From: Michael Eastham
Sent: 22 March 2019 08:44
To: Nicola Spencer
Subject: FW: Emerging outcomes of apportionment work and current S106 negotiations - A/40/18/OUT: Land North of Water Lane, Angmering

Highways England Planning Response (HEPR 16-01)

Council's Reference: A/40/18/OUT

Location: Land North of Water Lane, Angmering.

TITLE: PROPOSED IMPROVEMENT SCHEME TO A280 / A27 / TITNORE LANE ROUNDABOUT			
PROJECT: LAND SOUTH OF WATER LANE, ANGMERING		CLIENT: RYDON HOMES, GLEESON DEVELOPMENTS LTD

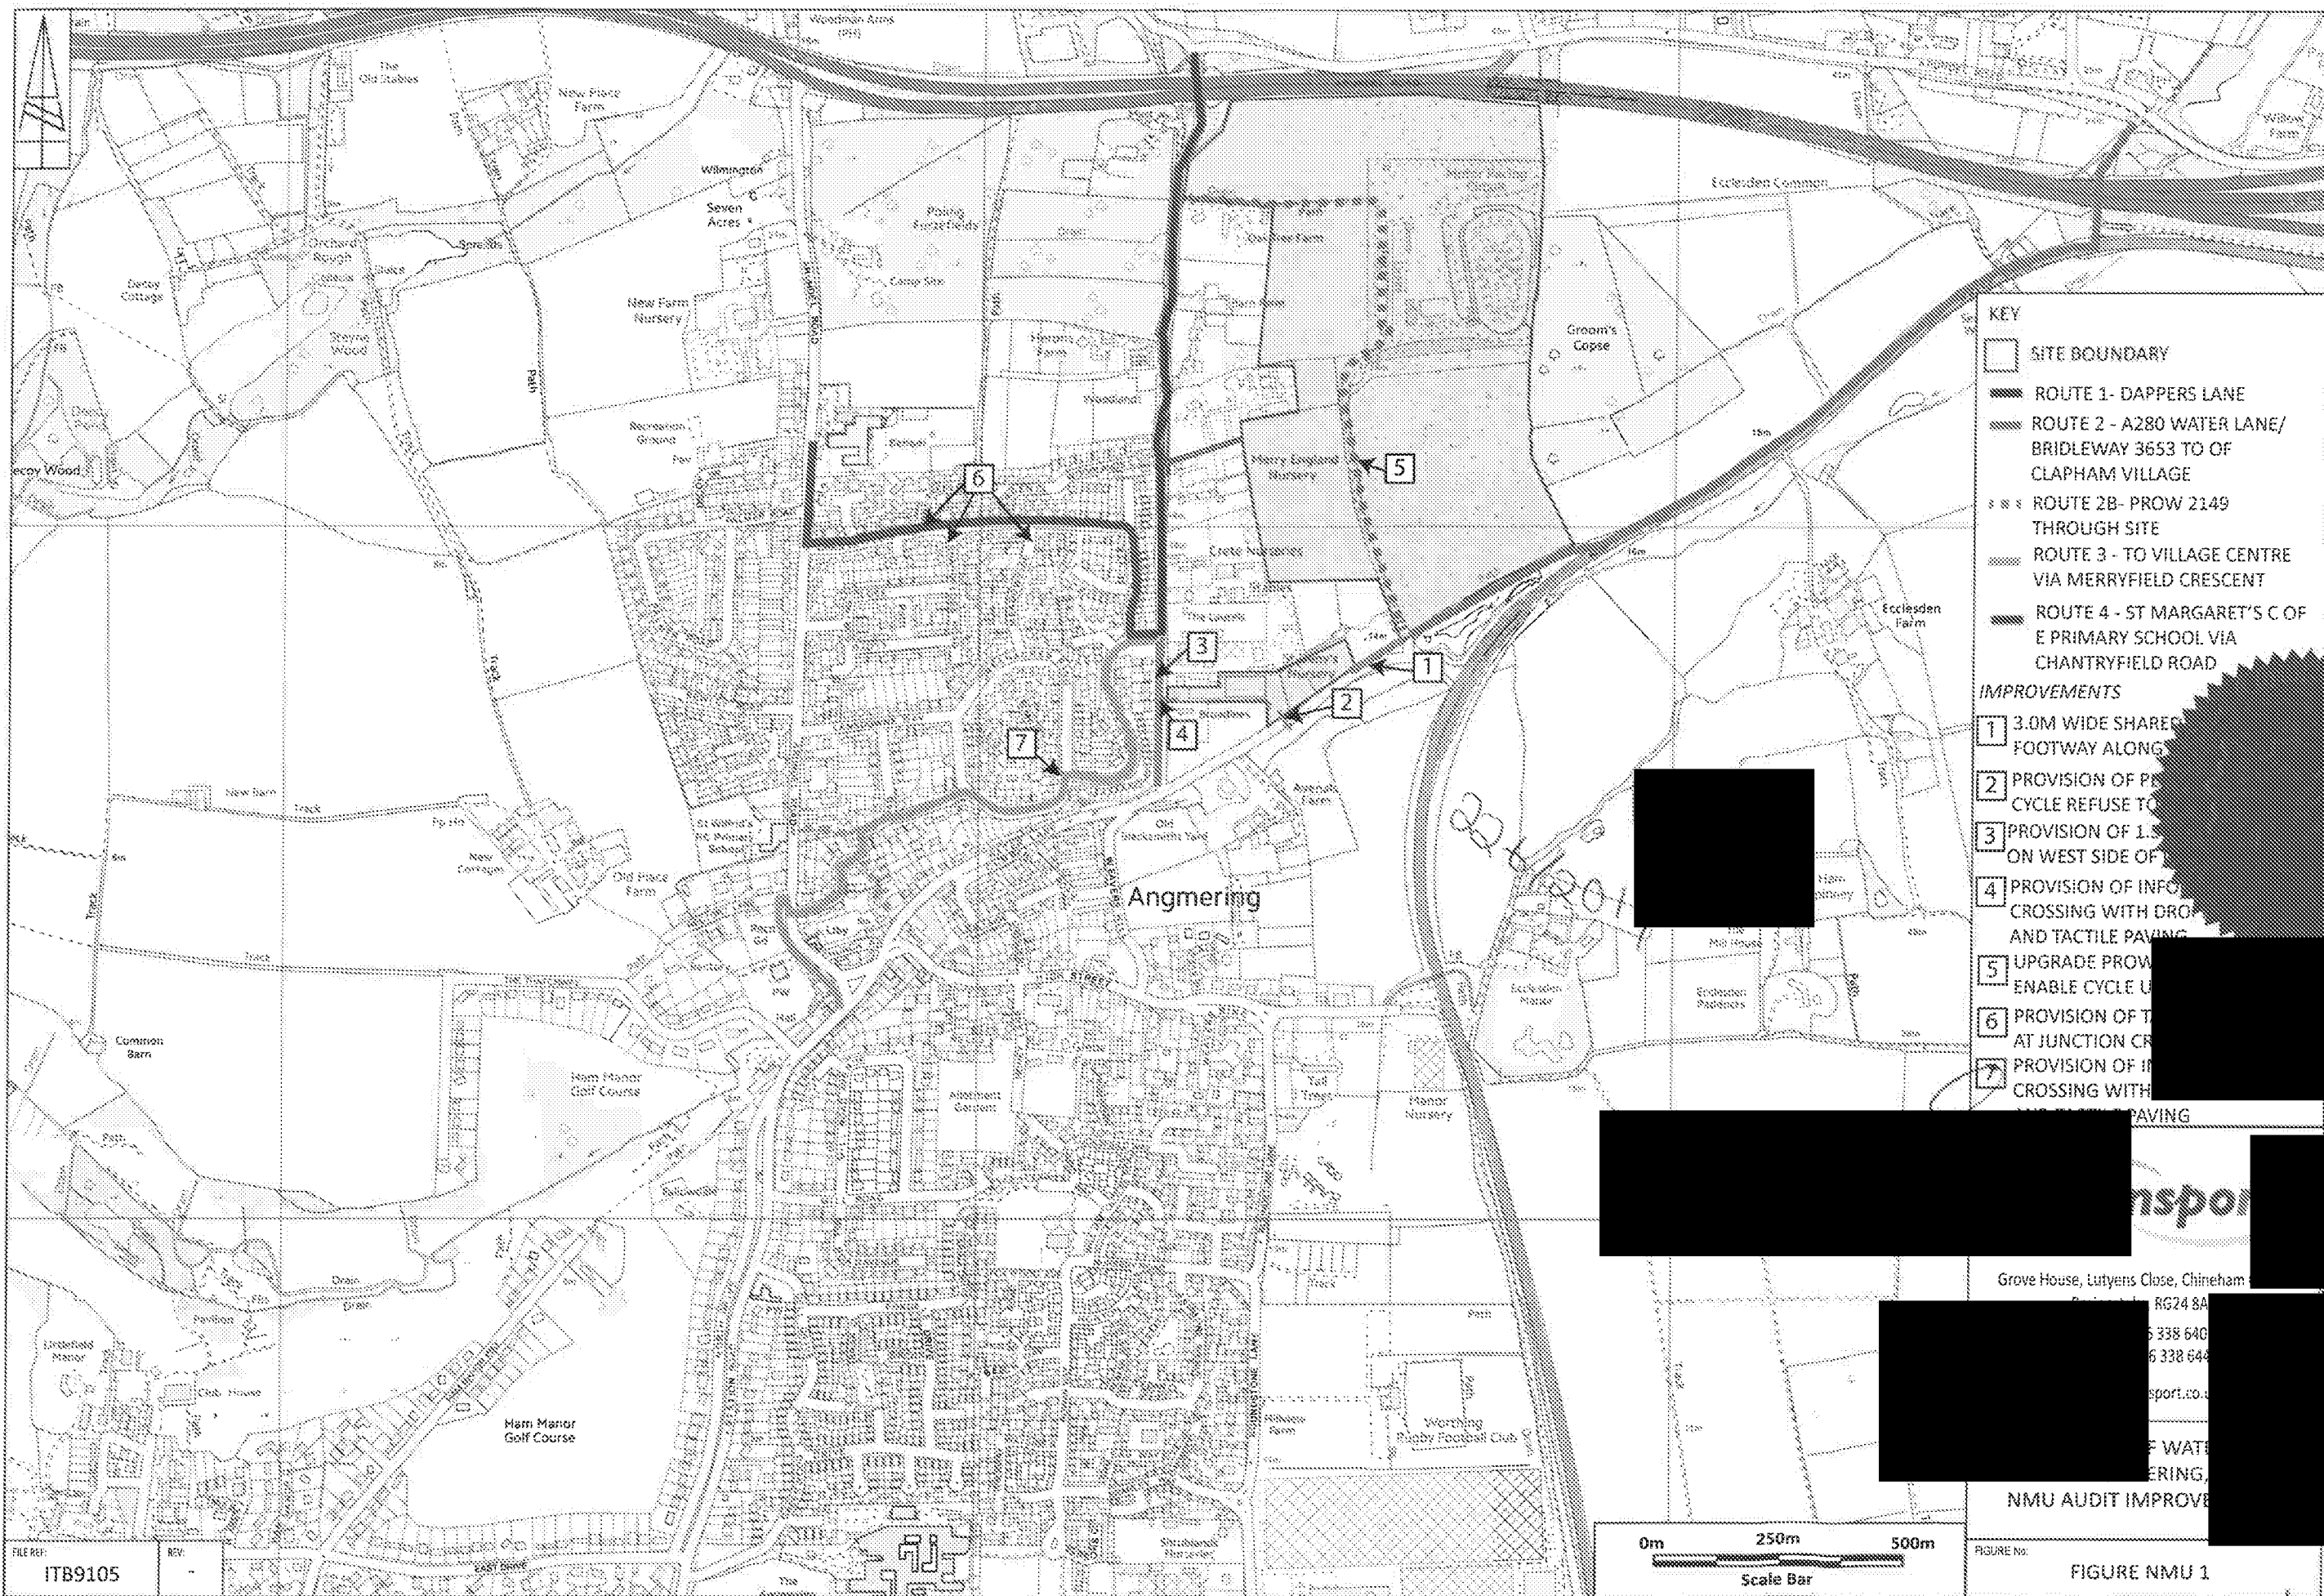
- 1) Prior to the occupation of 250 dwellings within the permitted development, the improvement works at the A280/A27/Titnore Lane Roundabout junction shall be completed and open to the travelling public as shown on i-Transport's drawing number "ITB9105-GA-024 – *Proposed Improvement Scheme to A280/A27/Titnore Lane Roundabout*" (or such other scheme of works substantially to the same effect, as may be approved in writing by the local planning authority (who shall consult with Highways England)), including any necessary transfer of lands to enable the construction and maintenance of the scheme.

Reason: The modifications have been proposed to provide sufficient capacity at the A280 / A27 / Titnore Lane Junction. This is to ensure that the A27 Trunk Road continues to be an effective part of the national system of routes for through traffic in accordance with section 10 of the Highways Act 1980 and to satisfy the reasonable requirements of road safety.
